Developer Services
Southern Water
Sparrowgrove House
Sparrowgrove
Otterbourne
Hampshire
SO21 2SW

Your Ref
BR/80/17/PL
Our Ref
PLAN-017925
Date
20/04/2017

Proposal: 1No. detached two bed bungalow. Resubmission of BR/163/16/PL.
Site: Land East of Pumping Station, High Croft Close, Bognor Regis, PO22 8DS.
BR/80/17/PL

PROPOSED GROUND FLOOR PLAN
& SITE BLOCK PLAN.

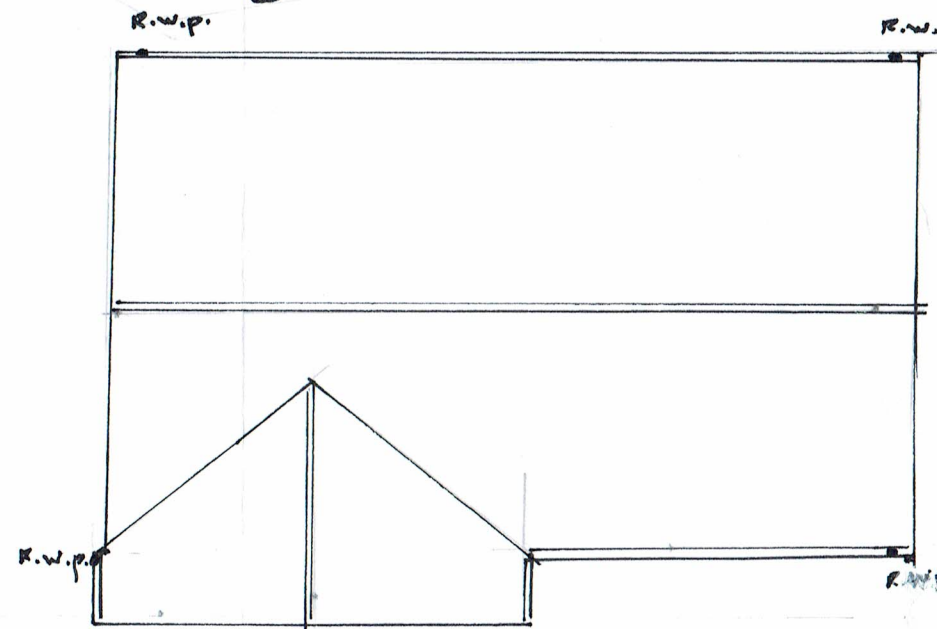
Southern Water objects to the proposed development as due to the vibration, noise and potential odour generated by sewage pumping stations, no habitable rooms should be located closer than 15 metres to the boundary of an existing pumping station site.
